## Local Policing Branch

**RE :-Manor Nursery High Street Angmering BN16 4AW**

Thank you for your correspondence of 6<sup>th</sup> April 2018, advising me of an Approval of reserved matters following outline consent A/51/14/OUT relating to appearance, landscaping, layout & scale for demolition of the existing Manor Nursery Garden Centre & hard standing & redevelopment for 32No.dwellings with associated access, public open space & landscaping for which you seek advice from a crime prevention viewpoint.

Drawing Title
**House Type A (plot 1- 6)
Plans**

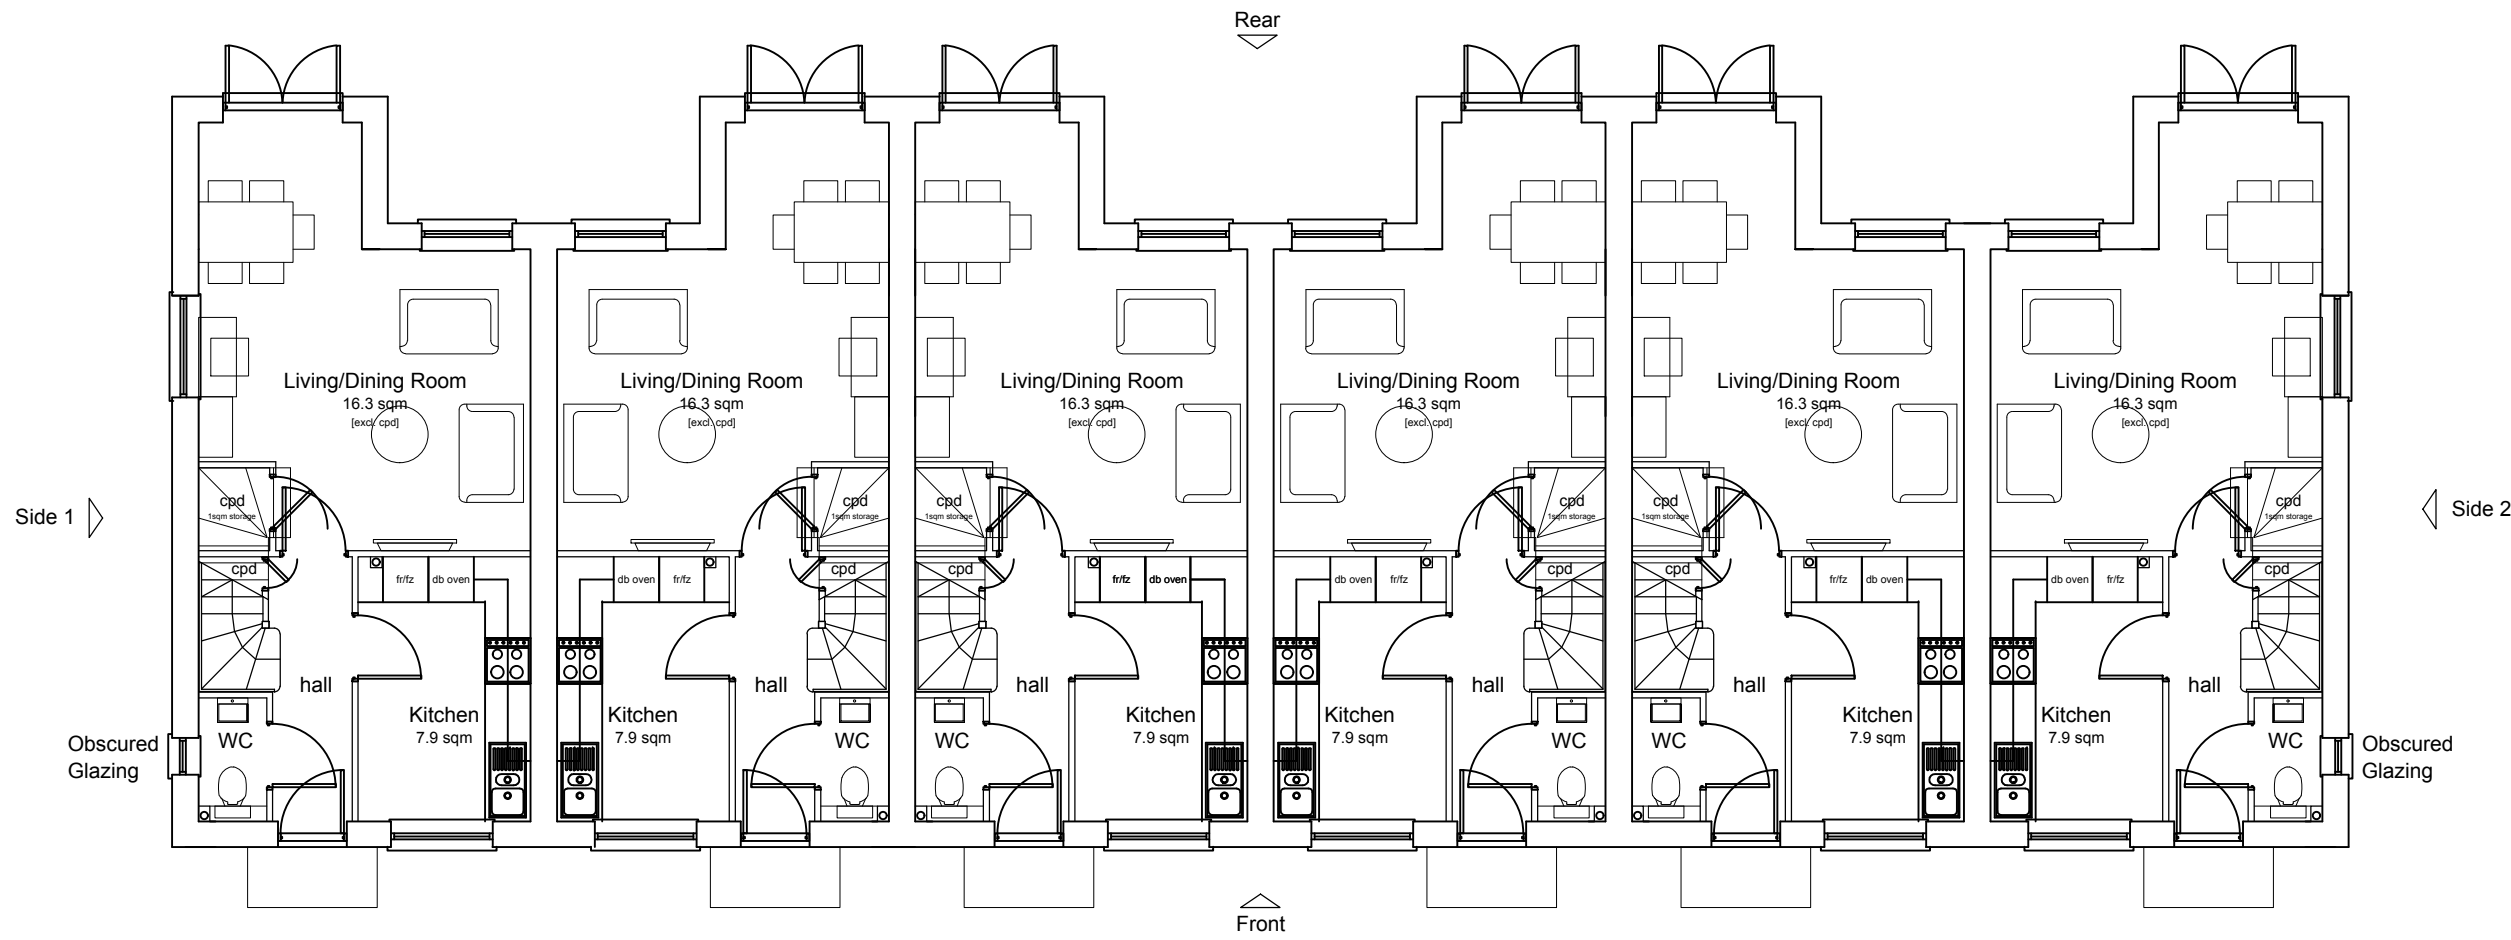
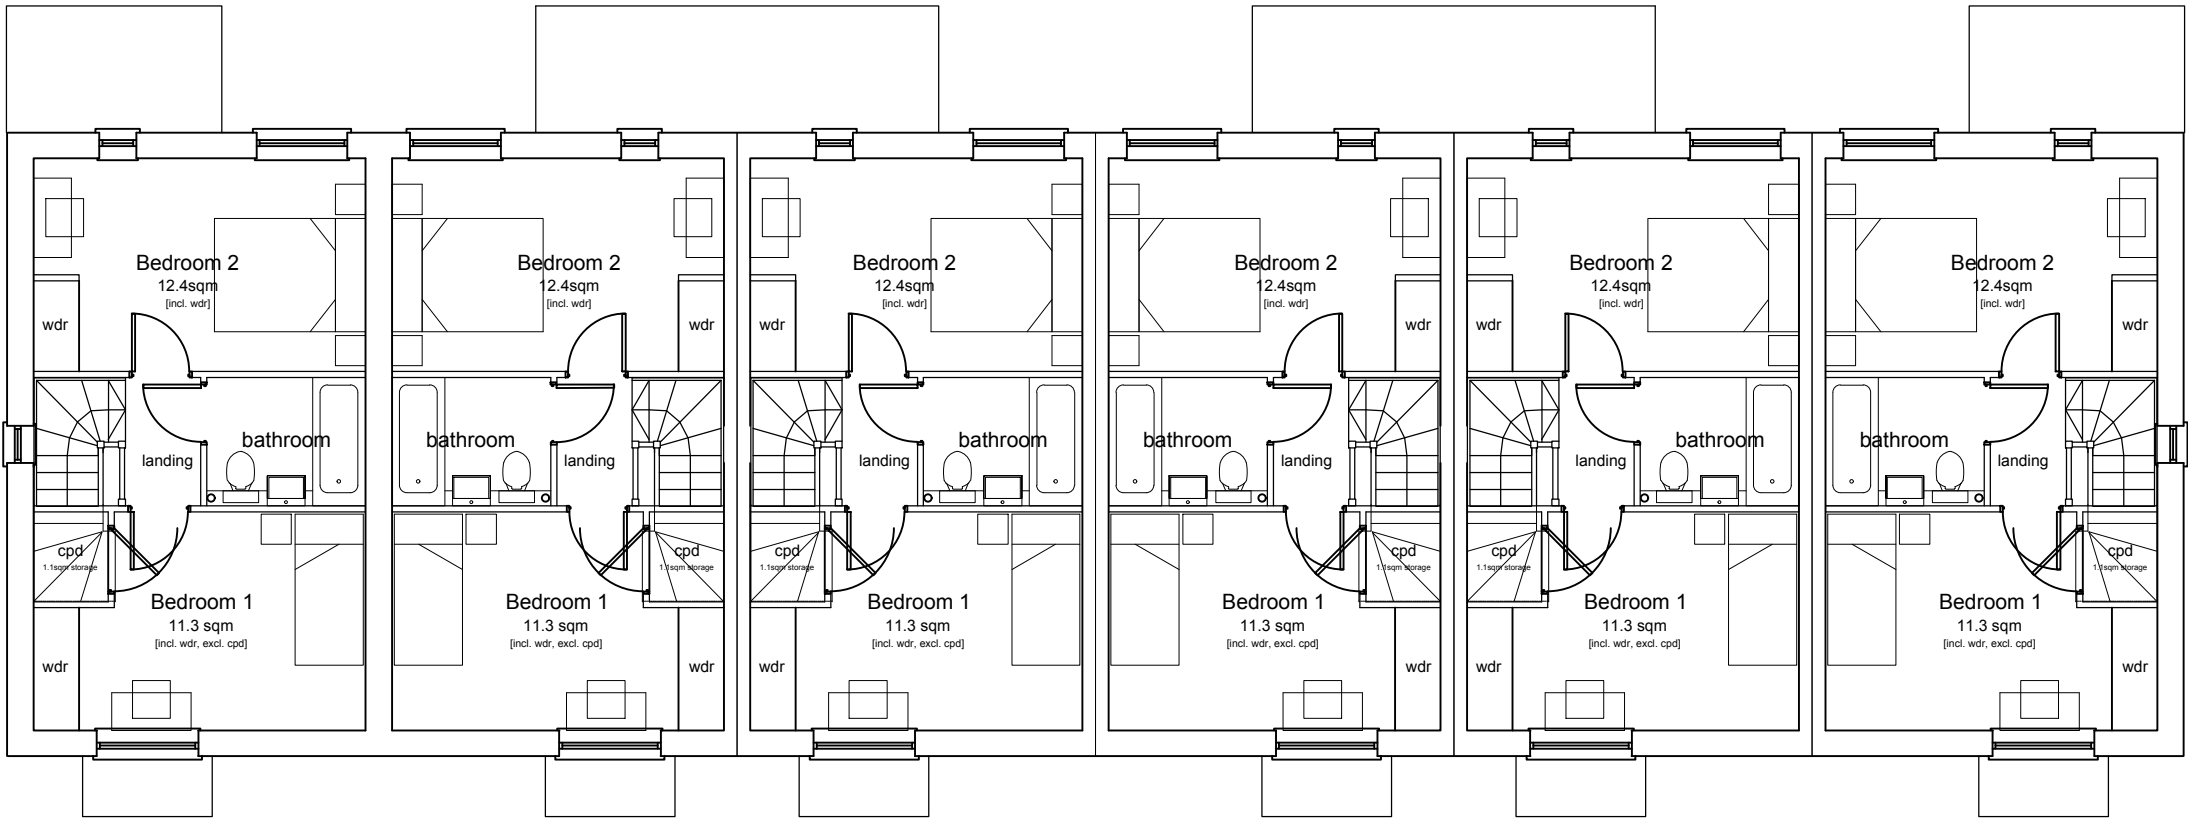
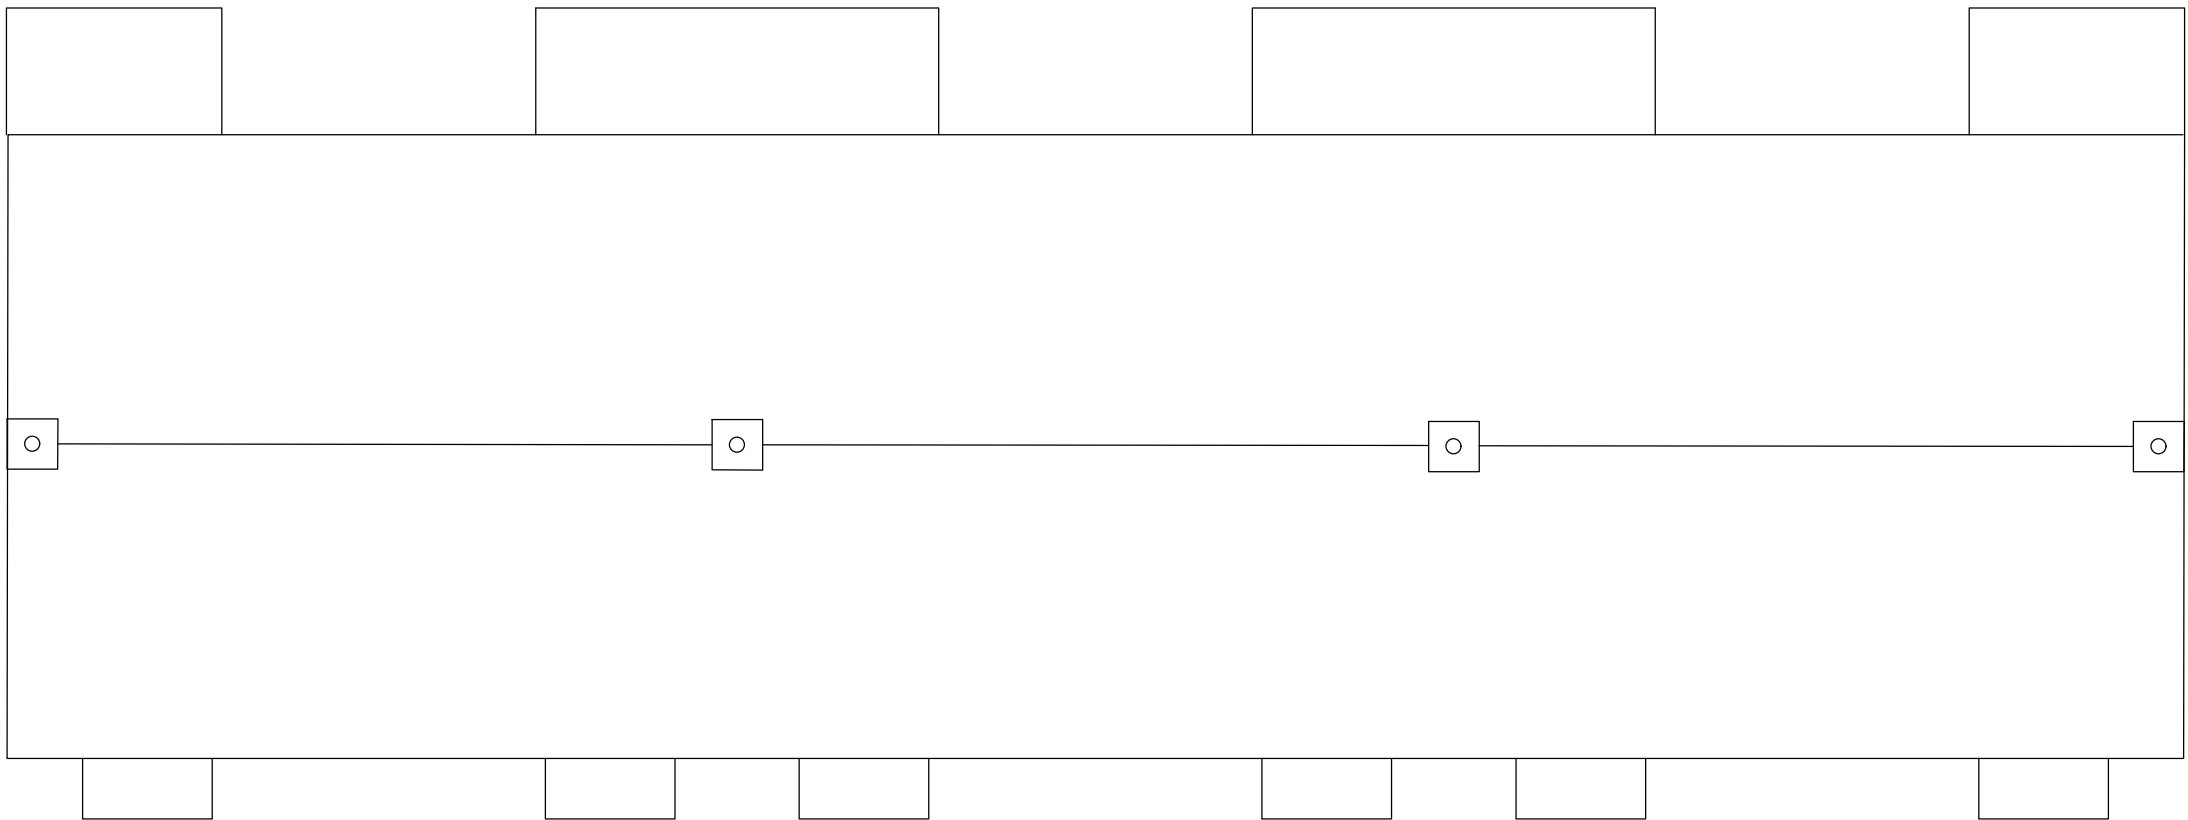
Plots 1 to 2 situated in the same block also have a rear footpath leading behind their gardens.

From a crime prevention viewpoint an alternative would be to provide controlled access gates at each end of the block of dwellings 1 to 6 located at the front, to completely prevent access to the back of each property by fitting two way locks and provide shared keys as appropriate for each end.

3.07 SITE LAYOUT

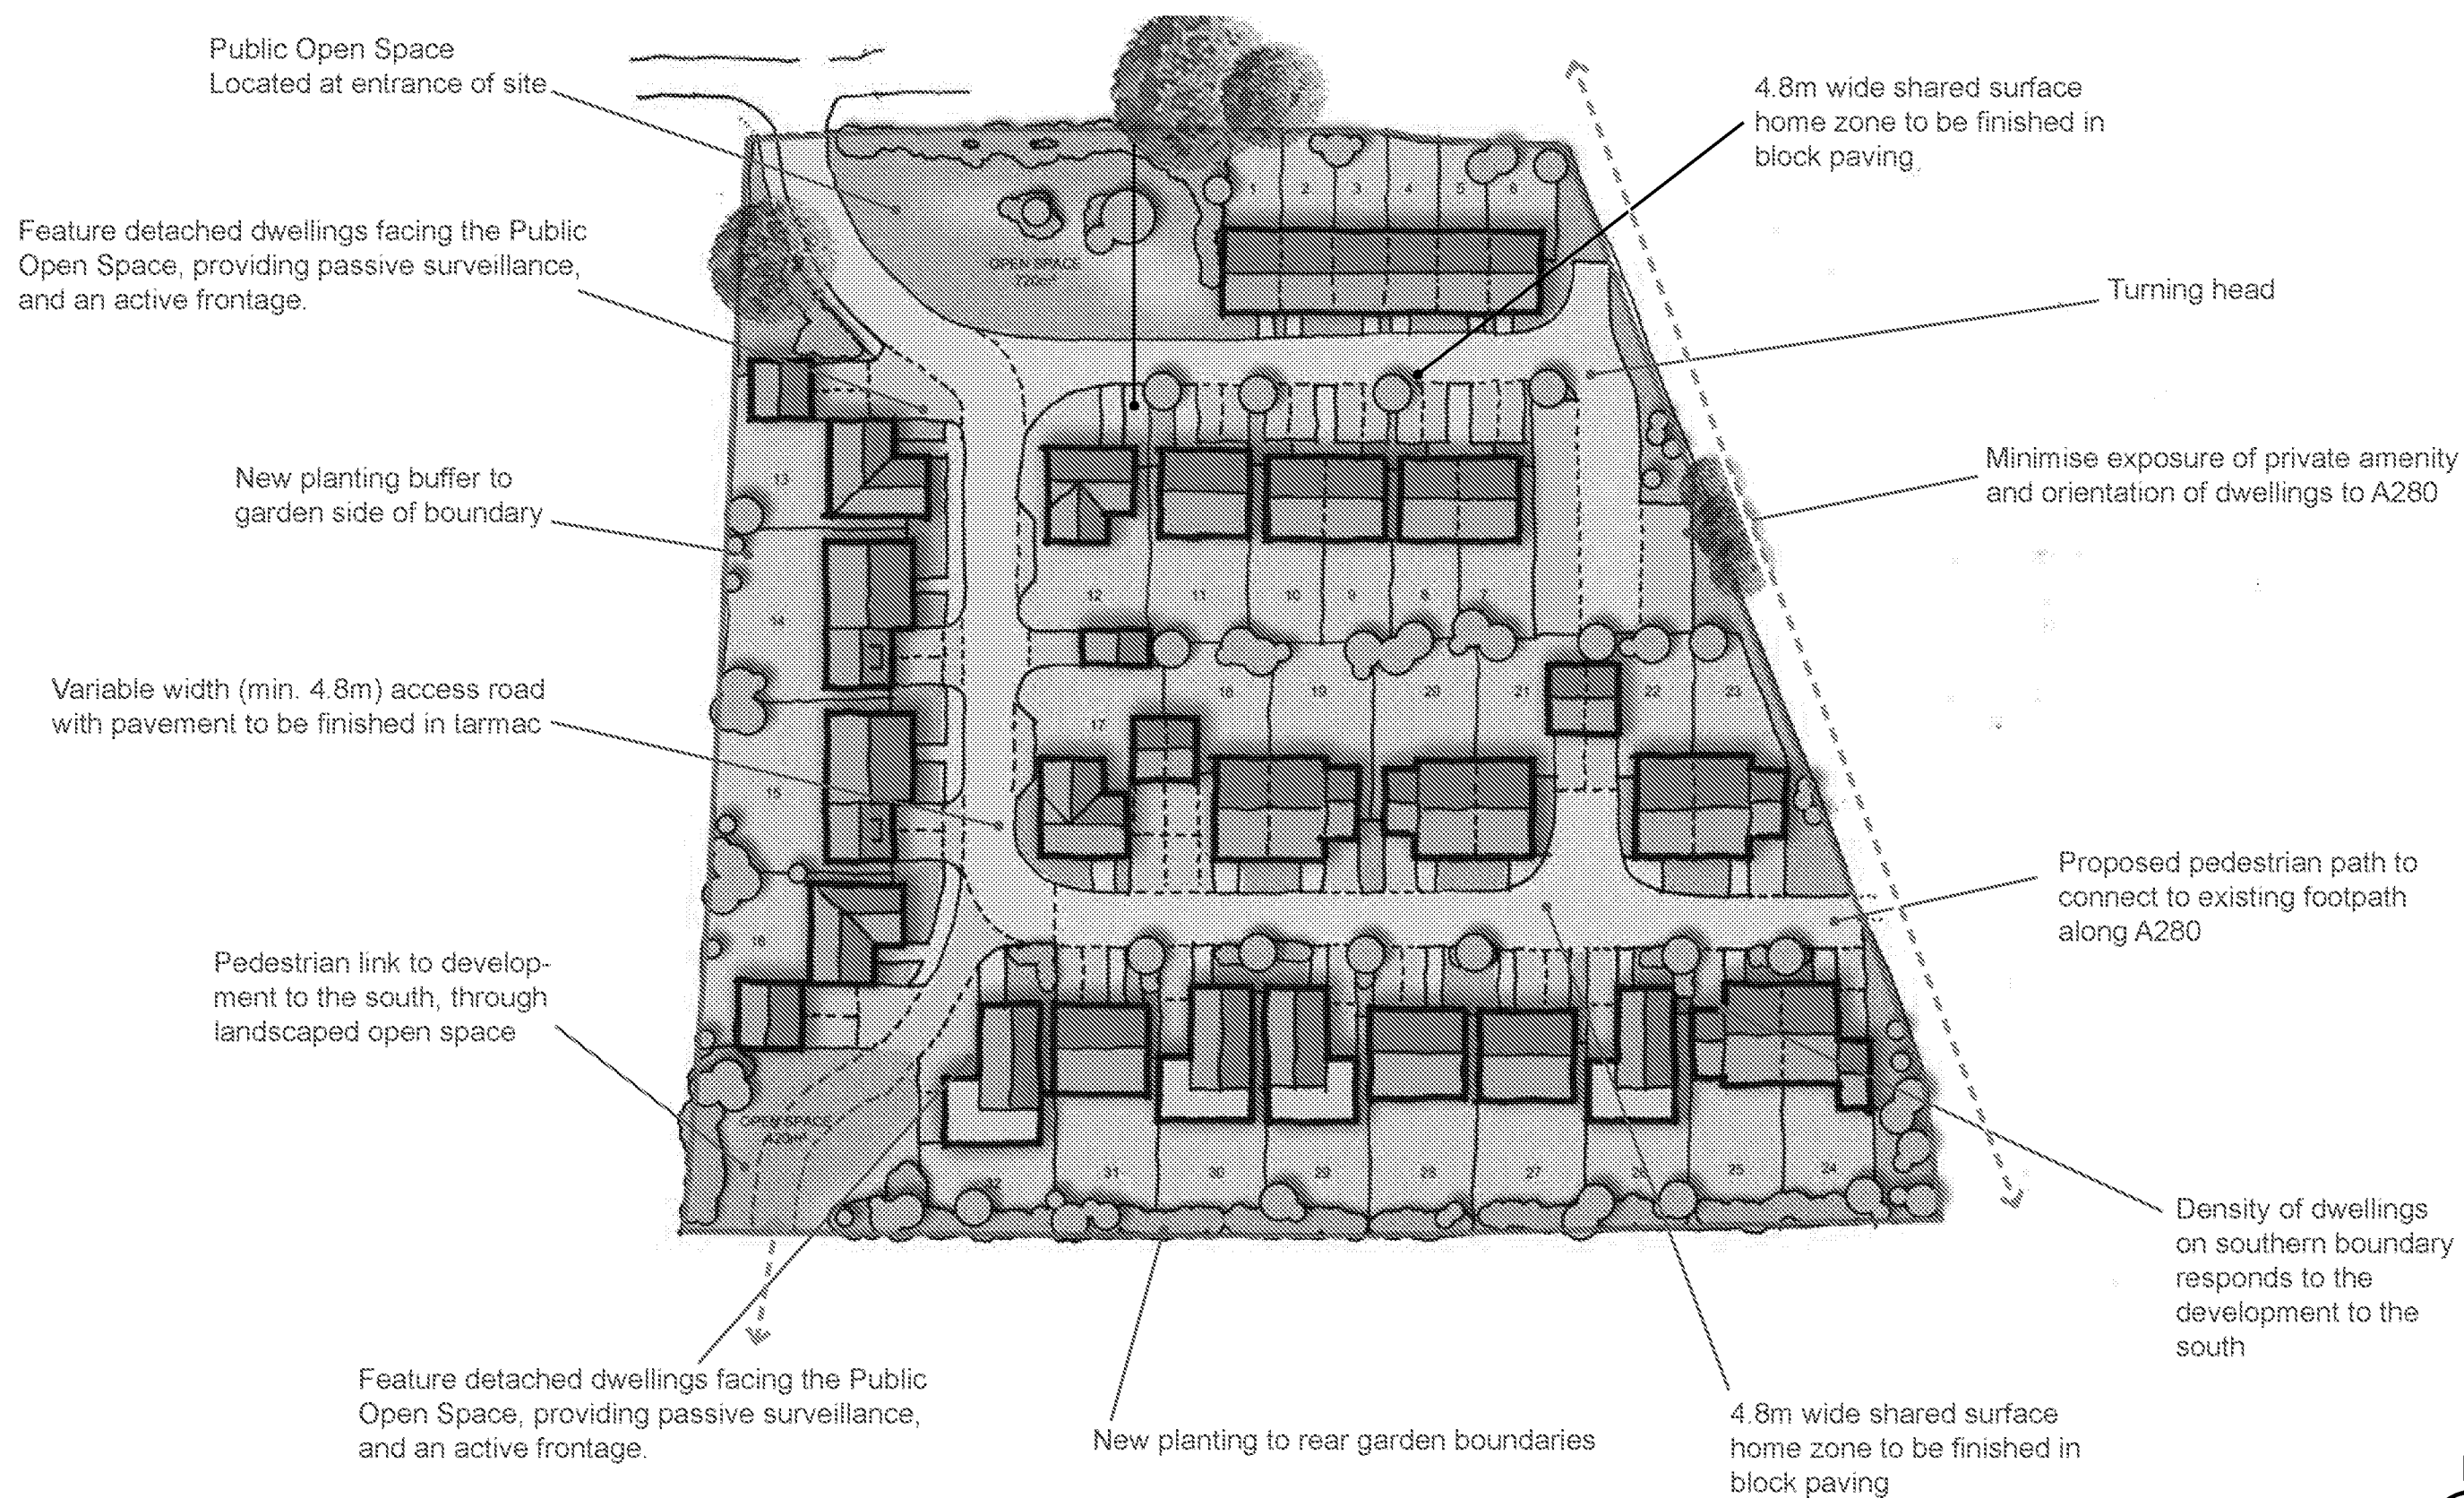
Plot 7 has a block of garages and two parking places on its eastern gable end which are vulnerable to crime from the public footpath entrance. In order to provide a casual overview of that area I would recommend a first floor gable ended window to the eastern elevation to view the turning head and public footpath entrance into the development.

This would be further enhanced by the same measure in the eastern gable ended wall of plot 6 on the opposite side of the road, as there is an ungated section of dwelling footpath leading to the back of the two properties No 5 and 6.

Although speeds will be low; on the west side of the development the building and the perimeter front wall of plot 13 may reduce visibility from the driveway, of north bound vehicles leaving the development, due to the curvature of the bend. The front wall or hedgerow should not exceed 1 metre in height to maintain a view across the bend.

Lighting throughout the development will be an important consideration and should conform to the recommendations within BS5489:2013. I would recommend the footpath through the public open space at the south west corner of the development should be illuminated.
